From: Amanda Scholes on behalf of Planning.Responses
Sent: 15 March 2018 11:27
To: Planning Scanning
Subject: FW: 4485 - Courtwick Littlehampton - variation of conditions 4 & 24 - Ref LU/408/17/PL

Just one amendment, please -- the spacing between the gates needs to be increased to 2.0m to ensure there is sufficient manoeuvring space between the barriers for mobility scooters and wheelchairs etc. Although I have only shown one gate amended, the corresponding one will also need to be lengthened (This also follows Sustrans guidance for such matters). The arrangement shown on the original is too tight:

DMA Strider Max 4 Mobility Scooter	1.440m
Overall Length	0.650m
Overall Width	1.225m
Overall Body Height	0.165m
Min Body Ground Clearance	0.650m
Track Width	2.00s
Lock to lock time	1.650m
Wall to Wall Turning Radius

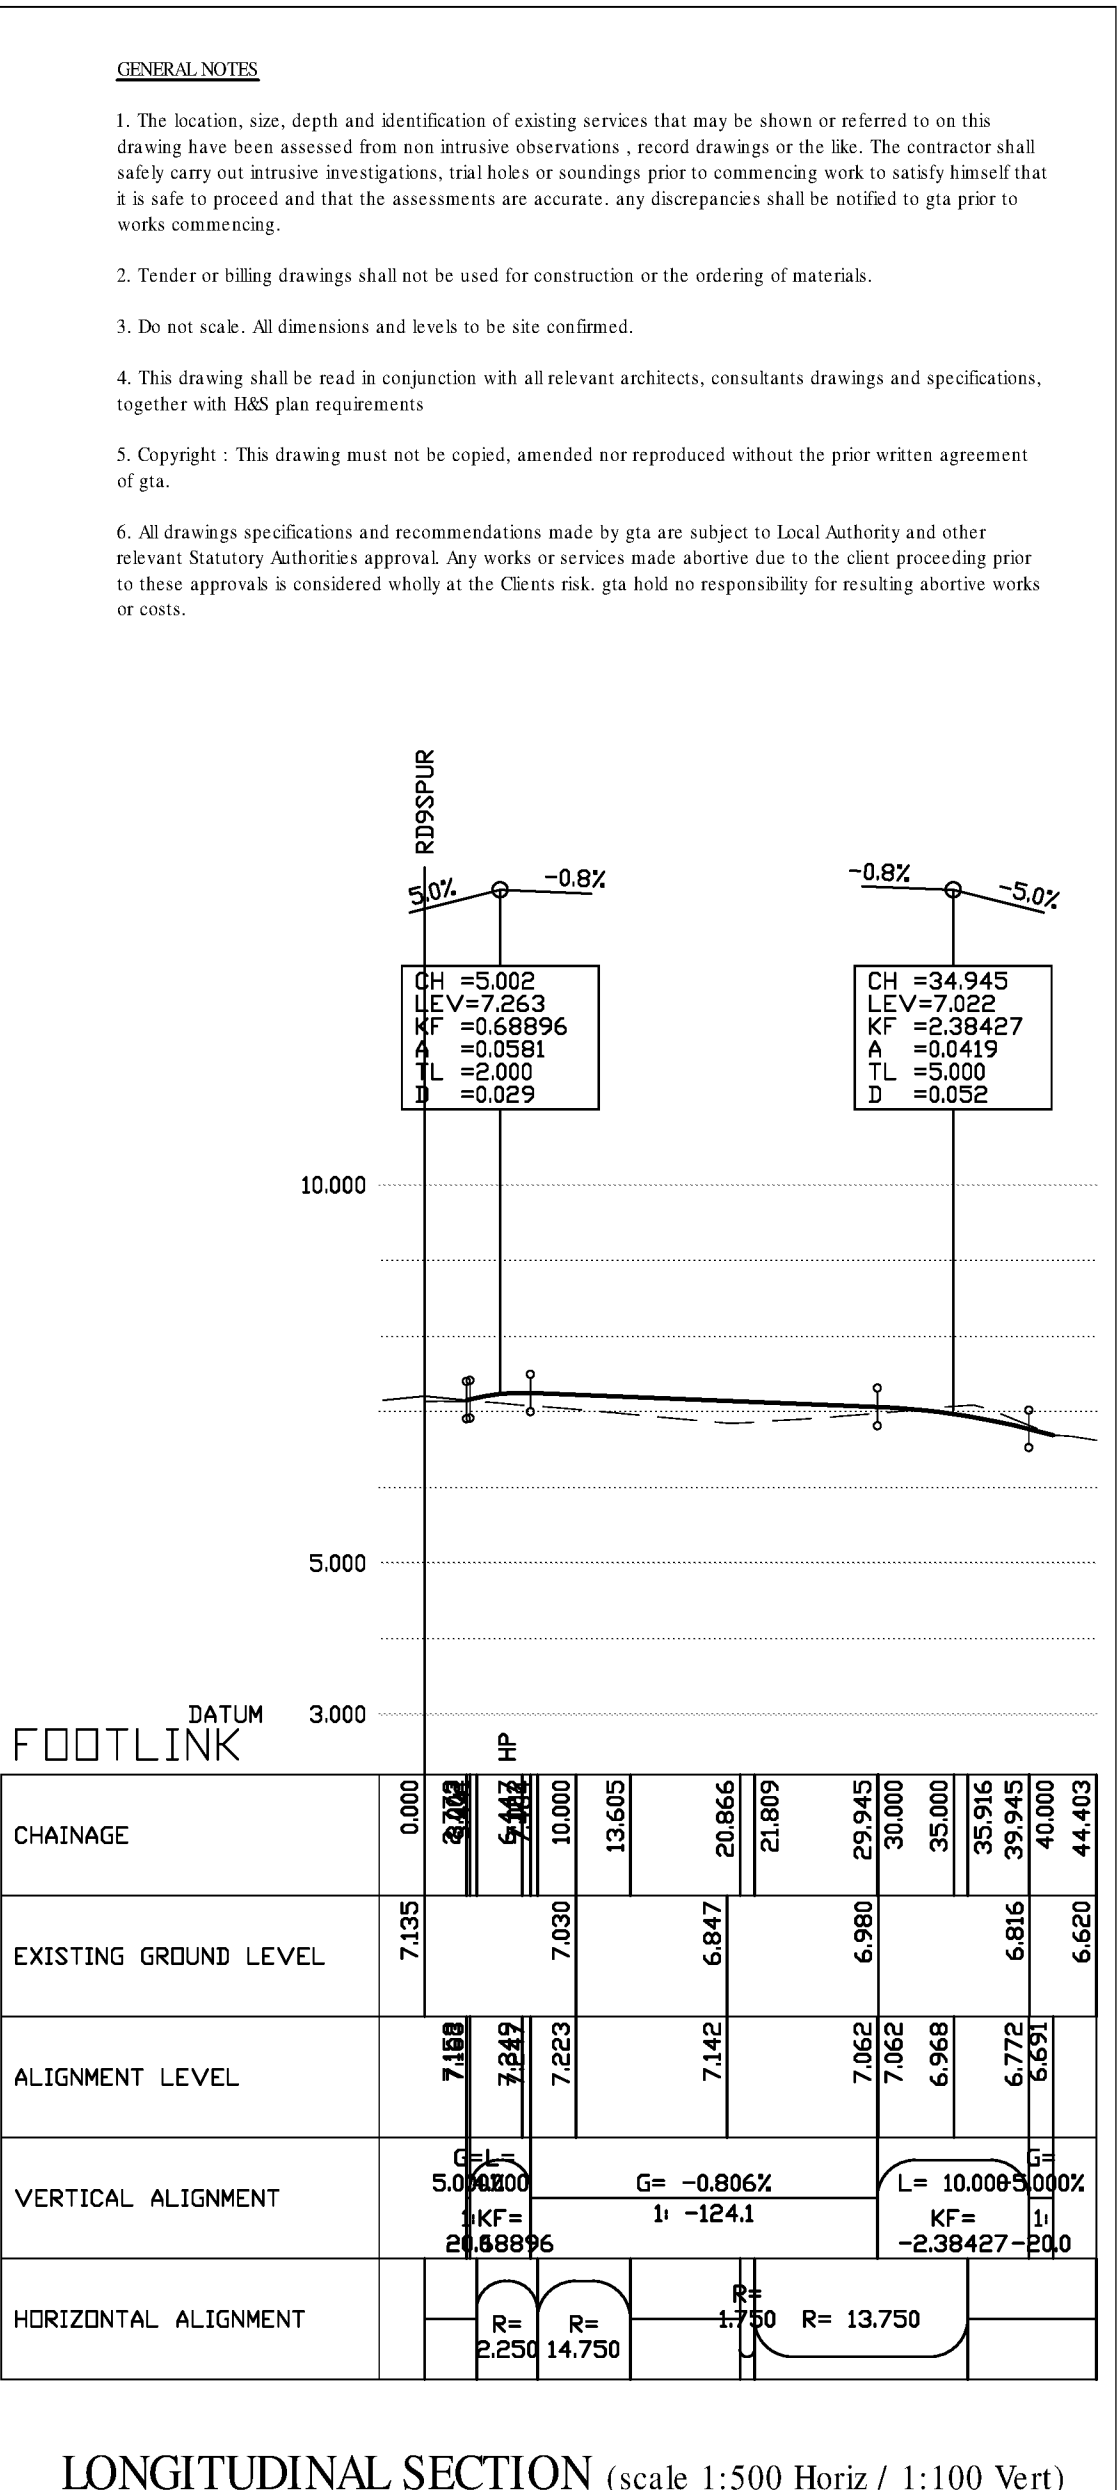
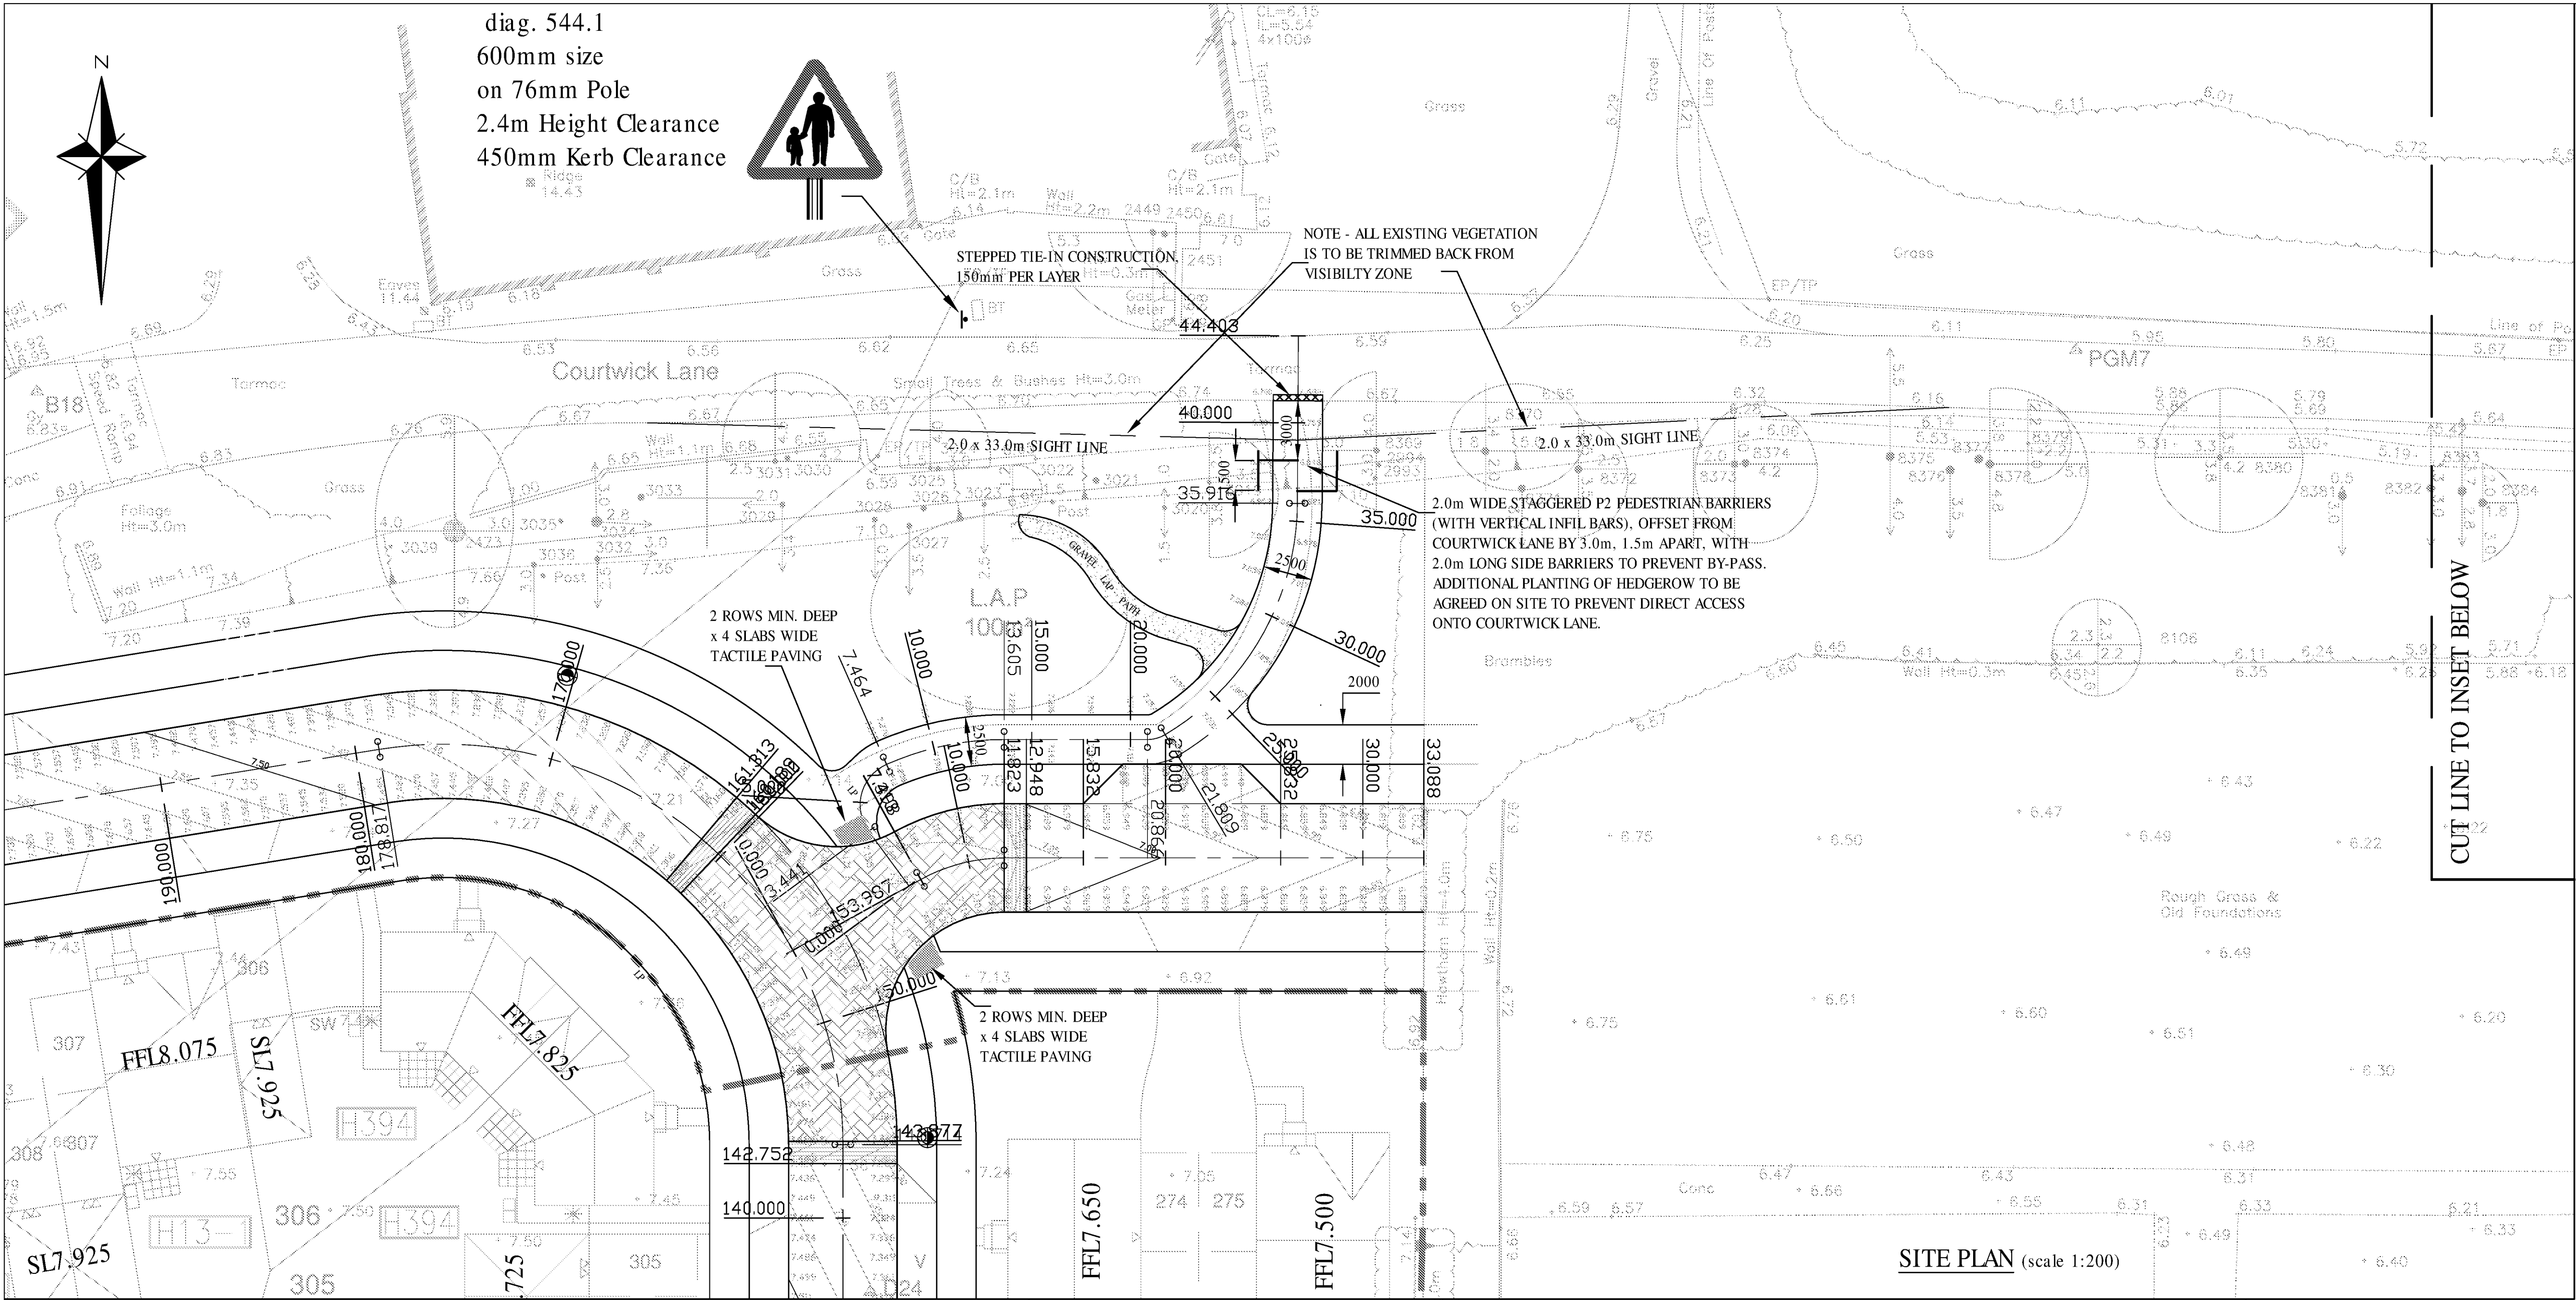
Also, I am taking it that the barrier will NOT be of the 'hooped-type' as originally proposed and of a type that prevents children from getting underneath (as shown in per one of my earlier emails)?

Further to Tim's additional comments, please find attached the updated Footpath Layout with adjusted barriers and additional notes regarding supplemental planting (tba on site).

The 'Sustrans' guidance does not provide a specification for non-cyclist barriers and the former was taken from the 'paths for all' guidance with a recommended spacing of 3m – though from 'Sustrans', this is acceptable for cycle use. I have reduced the spacing to 1.5m and have also provided a tracking diagram for a mobility scooter which confirms that this spacing should be acceptable.
